Date: 13/05/2022

Answers to Council's comments (05/05/2022): SuDS Report 49 Warren Way

Compiled by: S Ghimire, UK Flood Risk

Appendix H Proposed Surface Runoff Improvement Measures (SuDS)

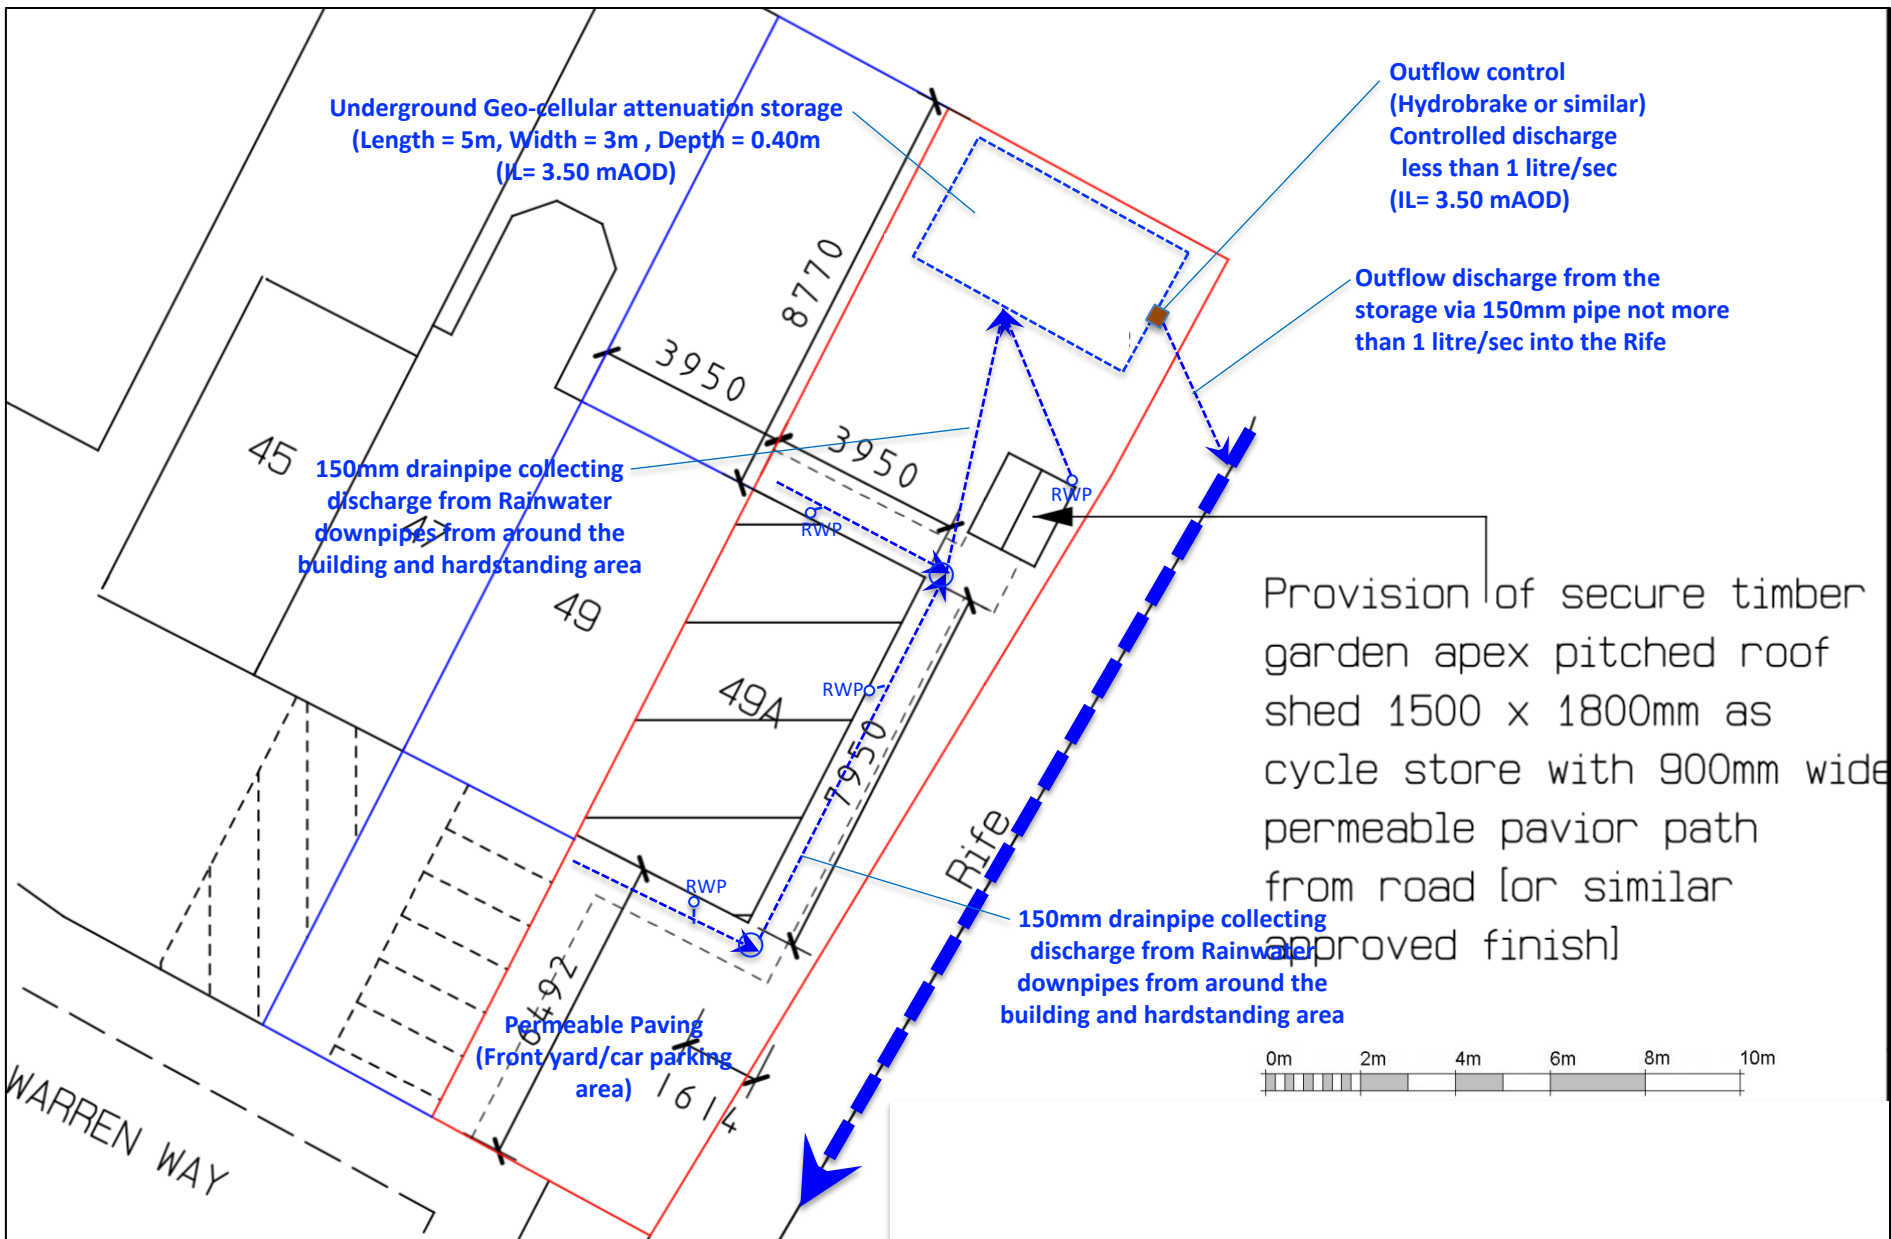
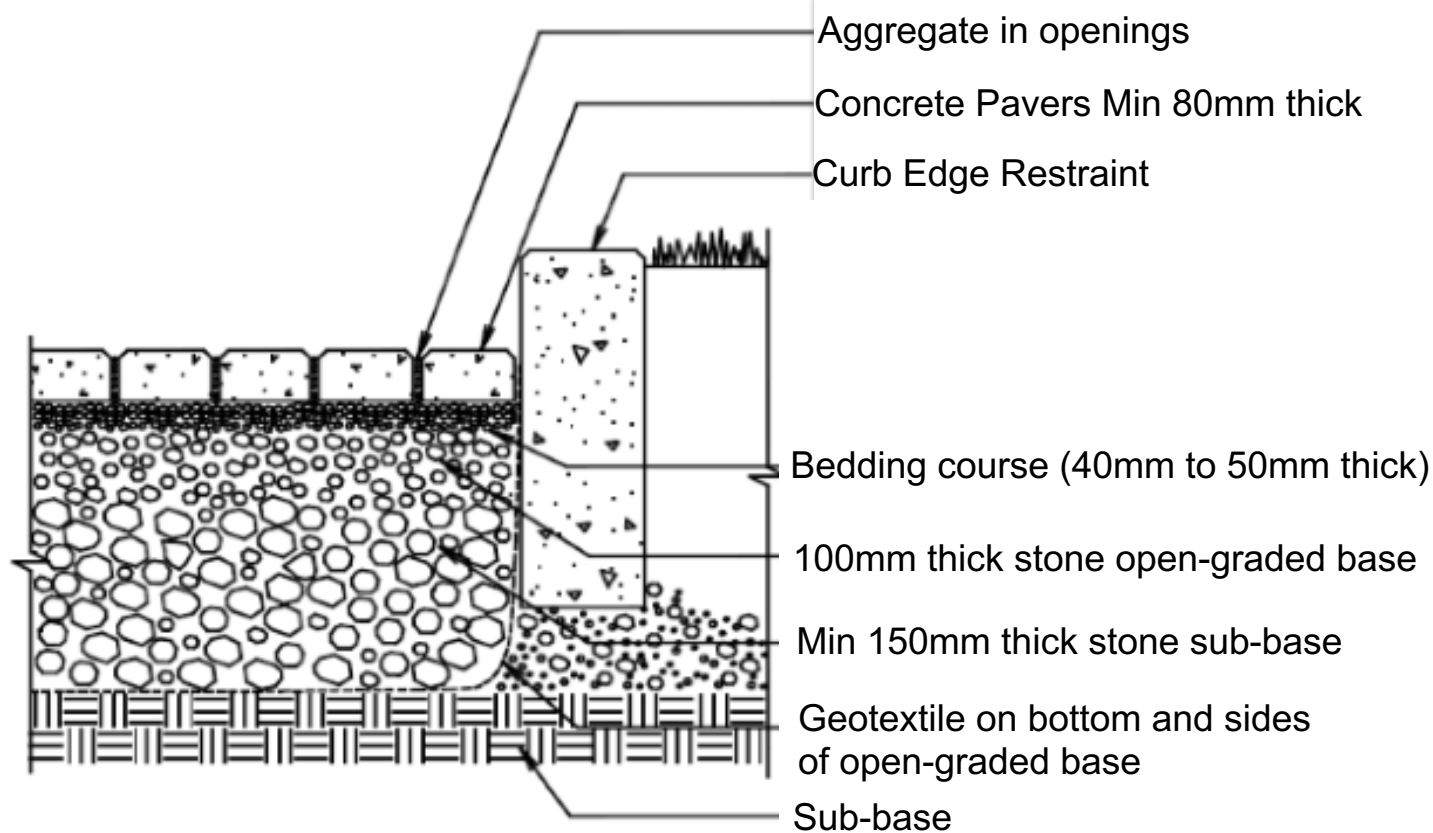
- b. *In addition to the details requested in the checklist, we would also expect specific details to include the following:*
 1. *The drainage design to include **all** drainage features, e.g. manholes, catchpits etc.*

8. *We also note that the 'sump available' option has been ticked in the drainage calculations. If a Hydro-Brake with sump available is specified, as is indicated by the calculations, this sump will need to be included on the drainage drawings. Please note that this sump cannot be substituted for the upstream sediment traps, that are also required.*

The details will be provided during the construction phase with a method statement.
 2. *Construction detail drawings of attenuation tanks, flow control devices, pipe bed and surround, headwall, and catchpits (which should be located upstream of the tank).*

Sump will be included on the drawings on the revised SuDS Report.

Unit Reference	MD-SCL-0038-5000-0300-5000
Design Head (m)	0.300
Design Flow (l/s)	0.5
Flush-Flo™	Calculated
Objective	Minimise blockage risk
Application	Surface
Sump Available	Yes
Diameter (mm)	38
Invert Level (m)	3.900
Minimum Outlet Pipe Diameter (mm)	75
Suggested Manhole Diameter (mm)	1200

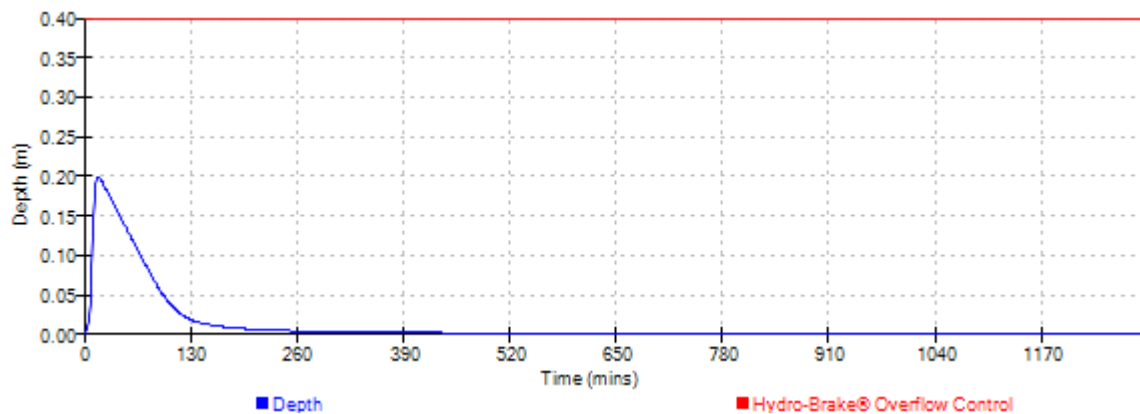
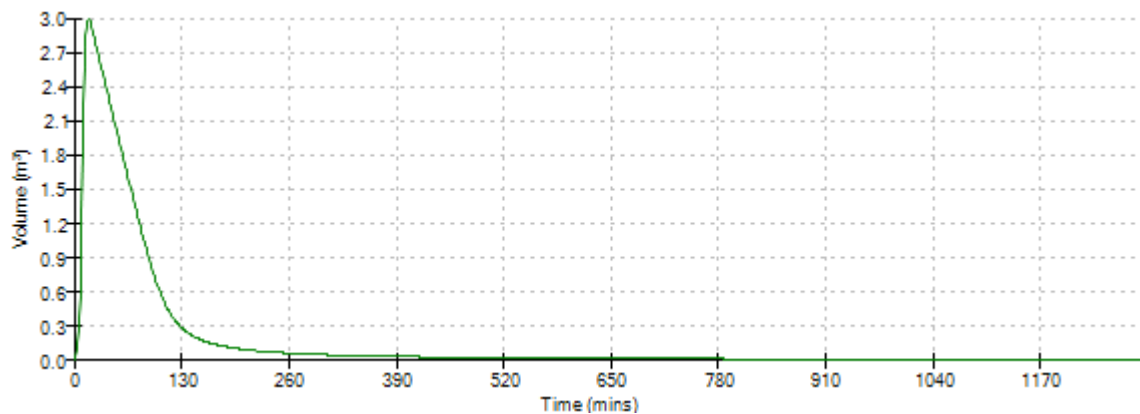
7. *The minimum orifice diameter for the Hydro-Brake and any flow control device will need to be 75mm, or have a minimum flow rate of 2.0l/s during the design rainfall event (unless sufficient evidence that a low blockage risk can be achieved is provided).*

Minimum outlet pipe diameter of 75mm has been used in the model (Refer Appendix I)
